KIRKLEES METROPOLITAN COUNCIL INVESTMENT & REGENERATION SERVICE

DELEGATED DECISION TO DETERMINE APPLICATIONS FOR CONSENT, AGREEMENT OR APPROVAL REQUIRED BY CONDITION

Reference No:	2026/44/90441/W
Site Address:	Huddersfield Bus Station, Upperhead Row, Huddersfield, HD1 2JN
Description:	Discharge of details reserved by conditions 11 (bins), 15 (BEMP), 22 (Phase II Intrusive Site Investigation Report) on previous permission 2025/91604 for variation condition 2 (plans) on previous permission 2024/92302 for refurbishment comprising (phase 1): facade improvements including Henry Street entrance; replacement shop fronts; alterations to external bus apron; extension and alterations to existing barrier within the bus alighting lane adjacent to Henry Street; (phase 2): new entrance canopy; public realm improvements; cycle hub; facade improvements including replacement shop fronts
Recommending Officer:	Liz Chippendale

DECISION – Discharge of Condition – Split Decision

P2 Proposed Bin Store Plan  
Scale: 1 : 50

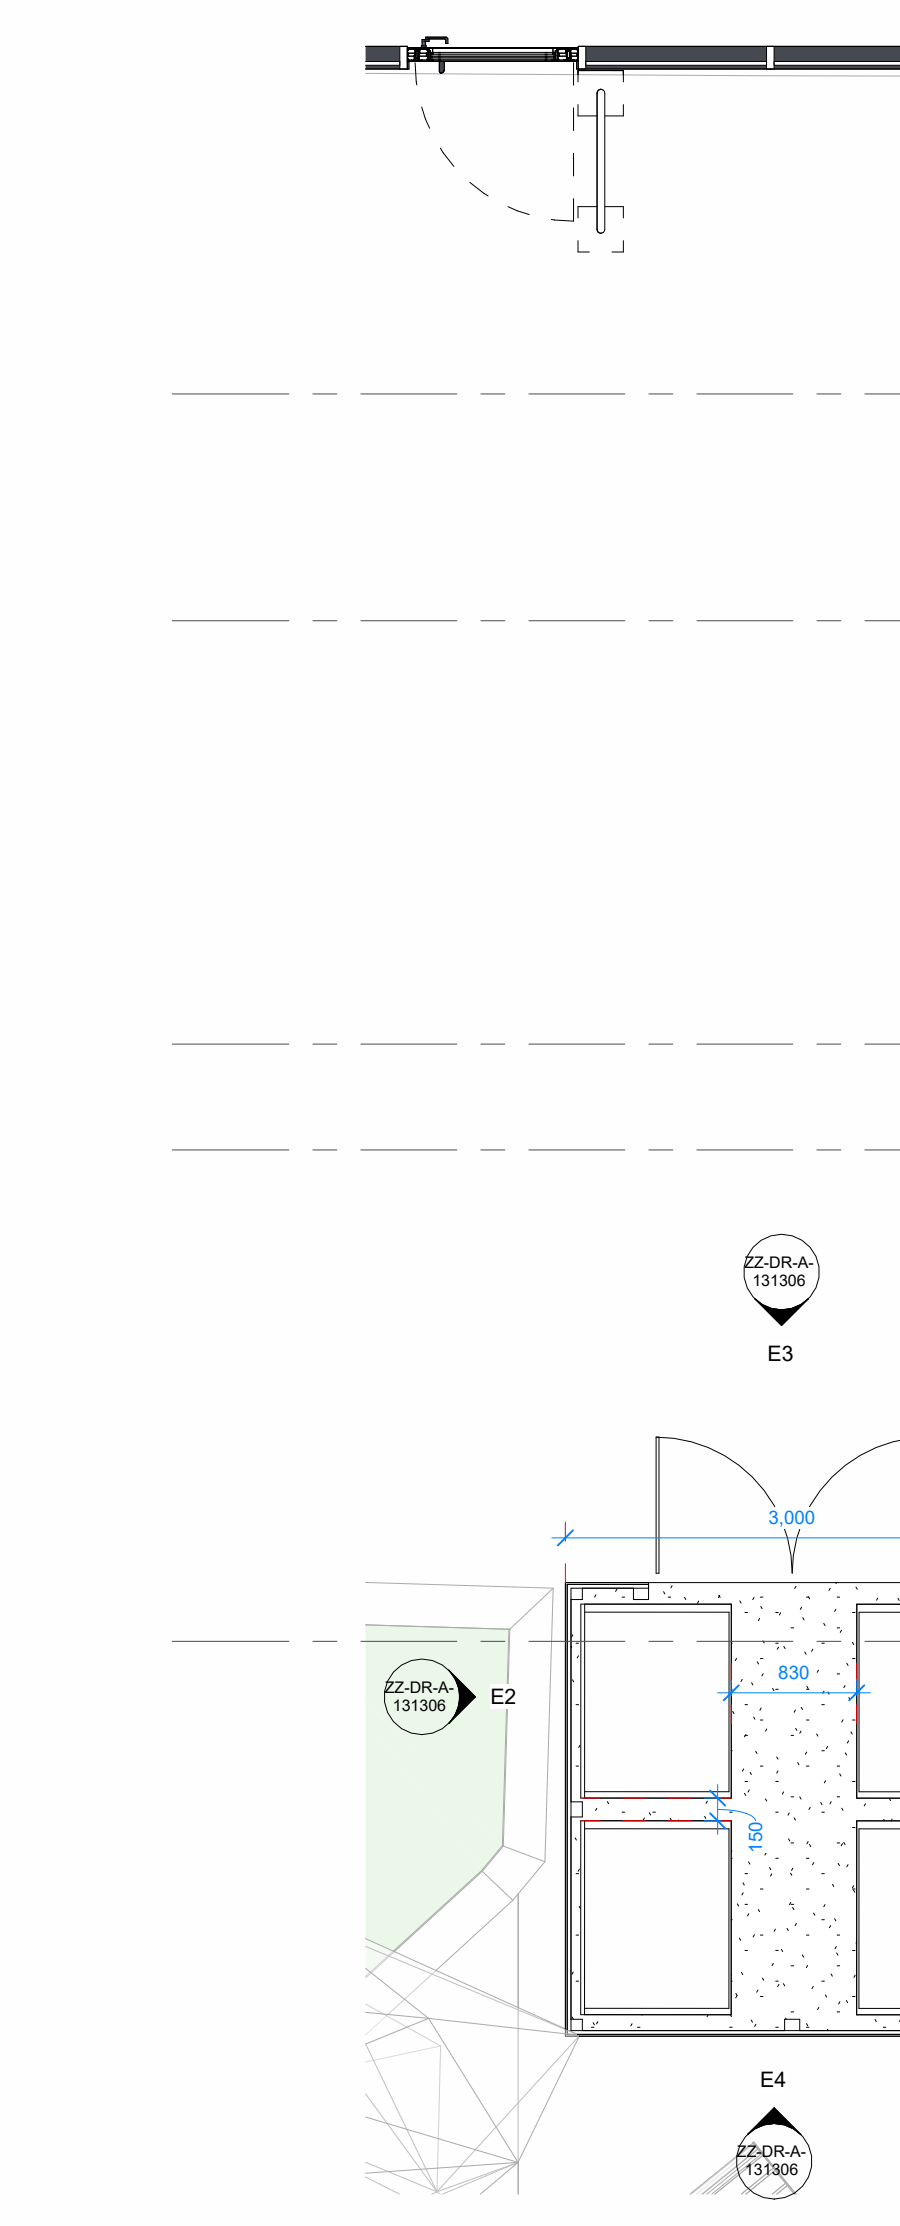
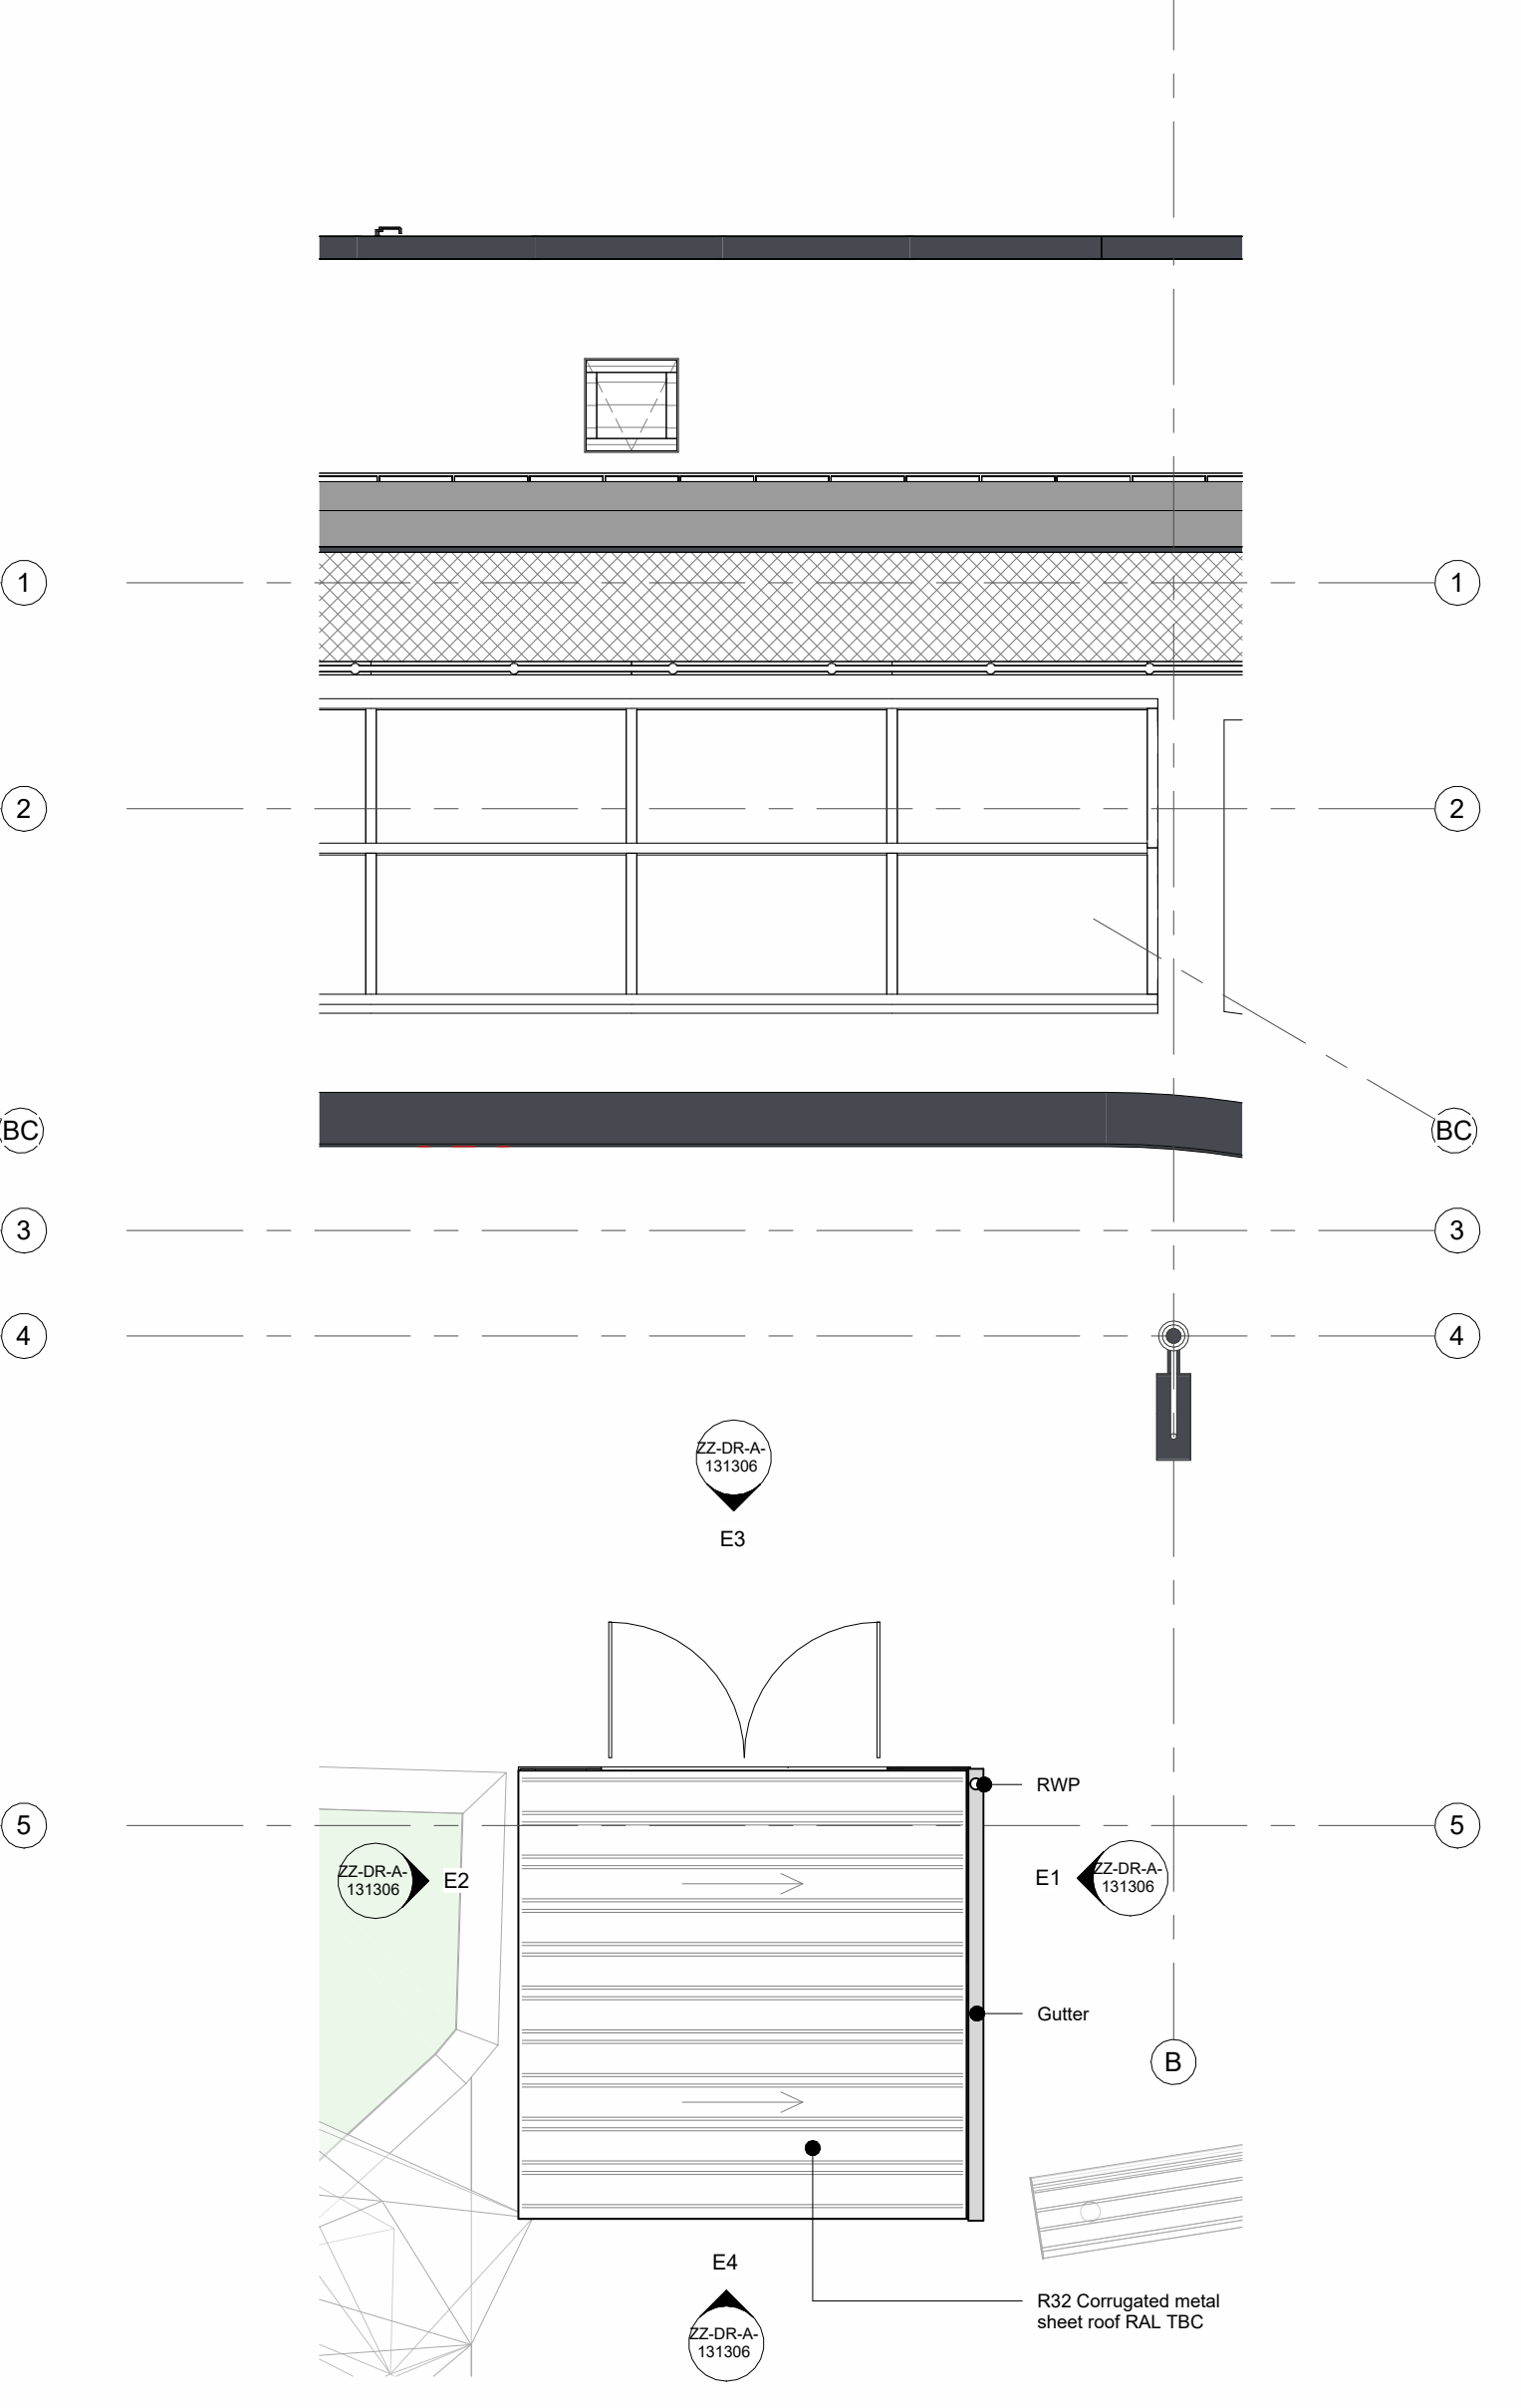
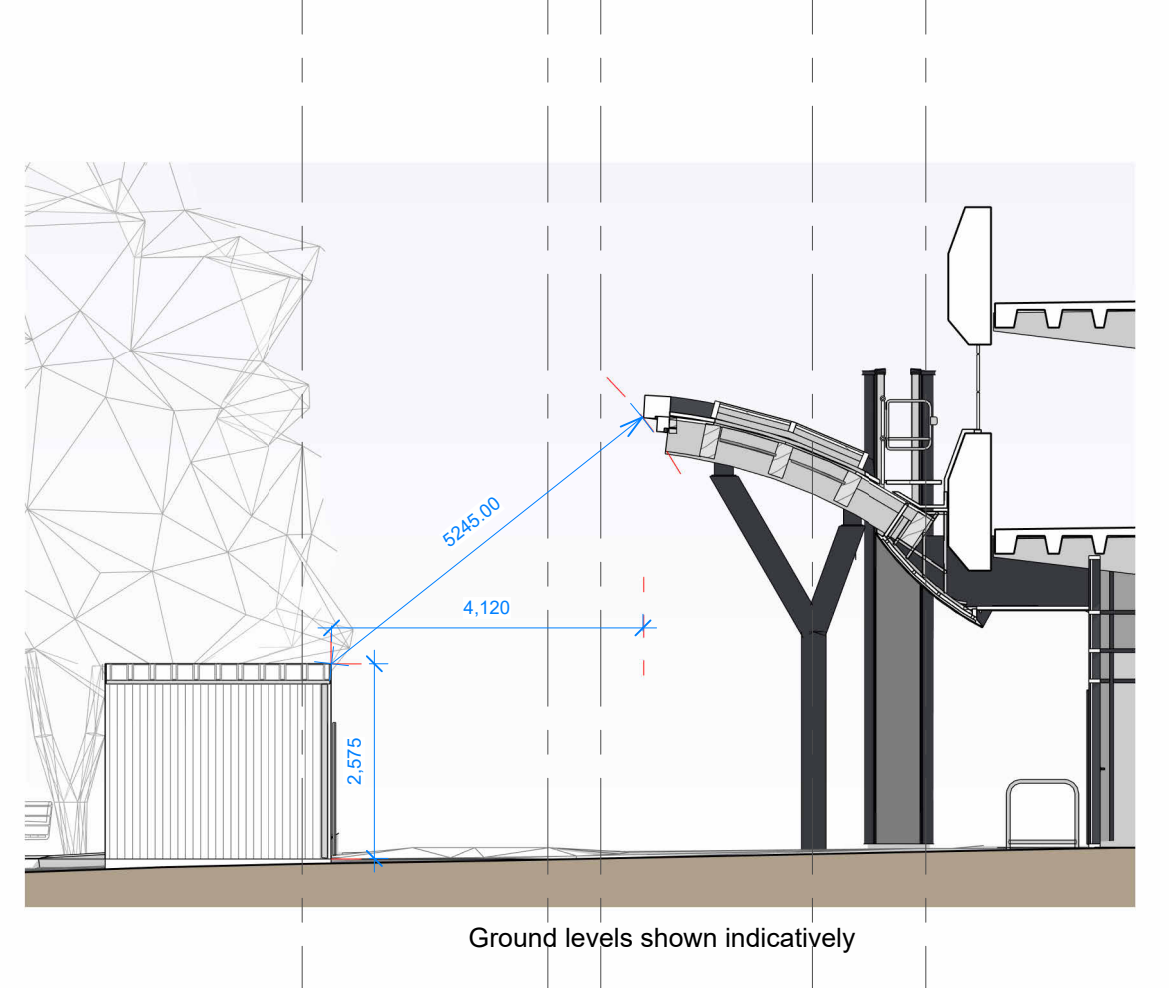
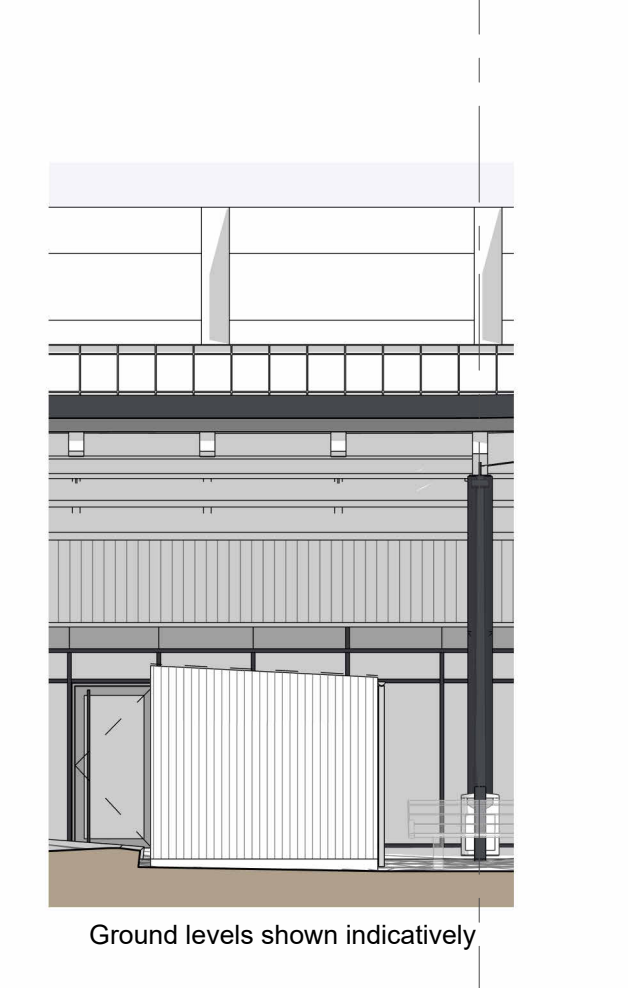
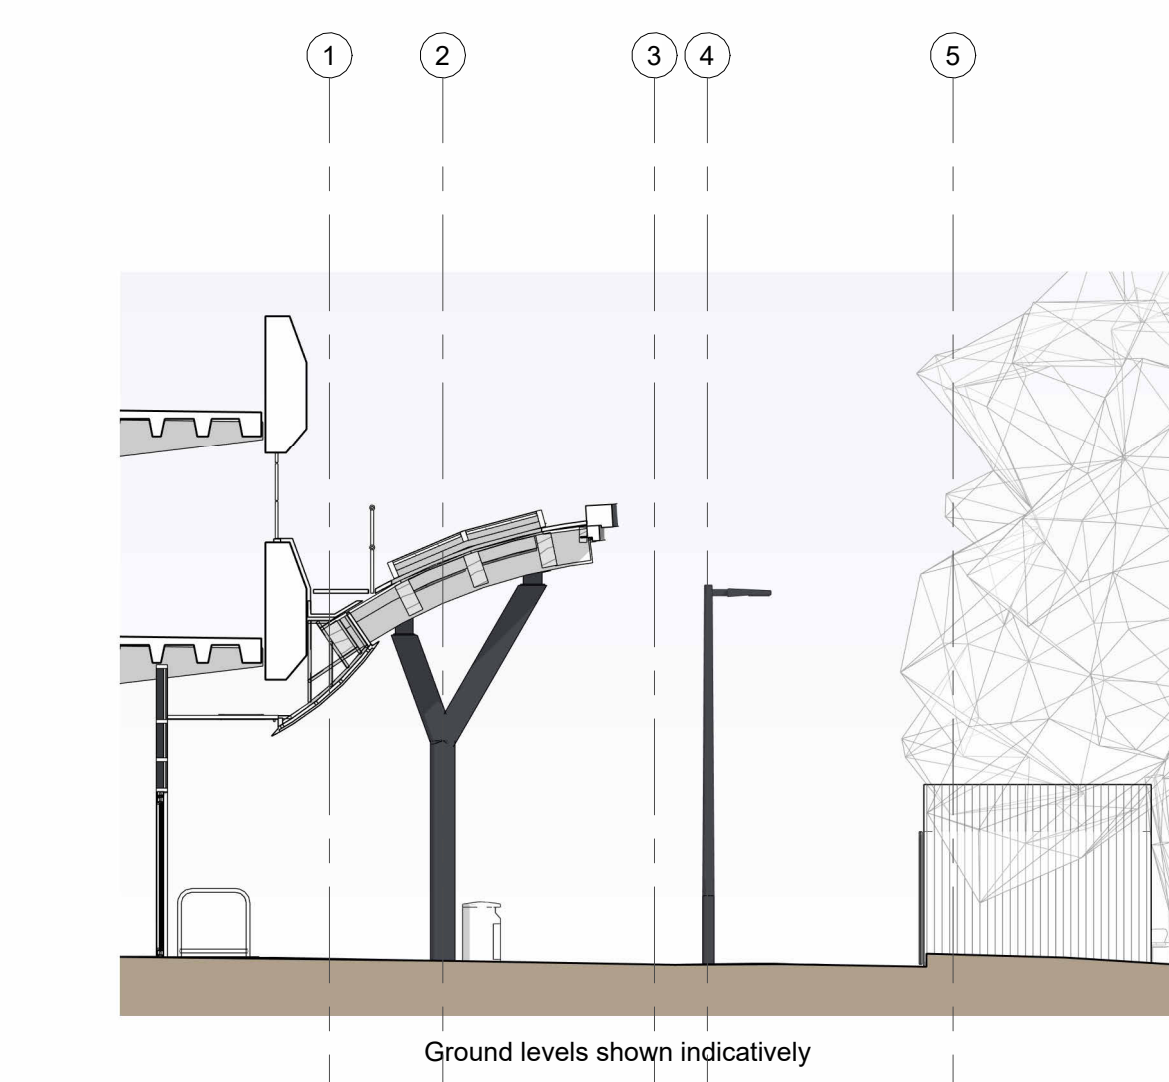
Part of the proposals are to formalise the existing bin storage located on the bus station forecourt on Upperhead Row with a wooden bin store that would remove the bins from open display in a prominent position on the pedestrianised area outside the bus station to enhance the street scene and bus station refurbishment.

It is noted that the location of the proposed bin store is within the adopted highway and is not included within the proposed stopping up zone underneath the new canopy. It is the Local Highway Authority's policy that formal bin storage should not take place within the adopted highway and because of this we would have submitted an objection to the proposals and requested that the condition should not be discharged.

The bin store only shows room for 4 bins, this is too small and needs to be larger to be able to accommodate 8 bins that are currently on the site. Given the information provided by the developer the WCA cannot agree to the Discharge of Condition 11 for the site until the bin store is made larger.

We would not wish to see a precedent set that will allow other developments within town centre locations to propose waste stores on the adopted highway in contravention to existing LHA policy. However, given the information presented above, for this specific instance only, we would, on balance, not wish to object to the discharge of condition 11 of 25/91604.

I understand now where the 4 containers figure came from and that the other waste containers are to be dealt with by the Bus Station. Therefore, I am happy with the bin store holding the 4 containers as detailed in the latest plan.
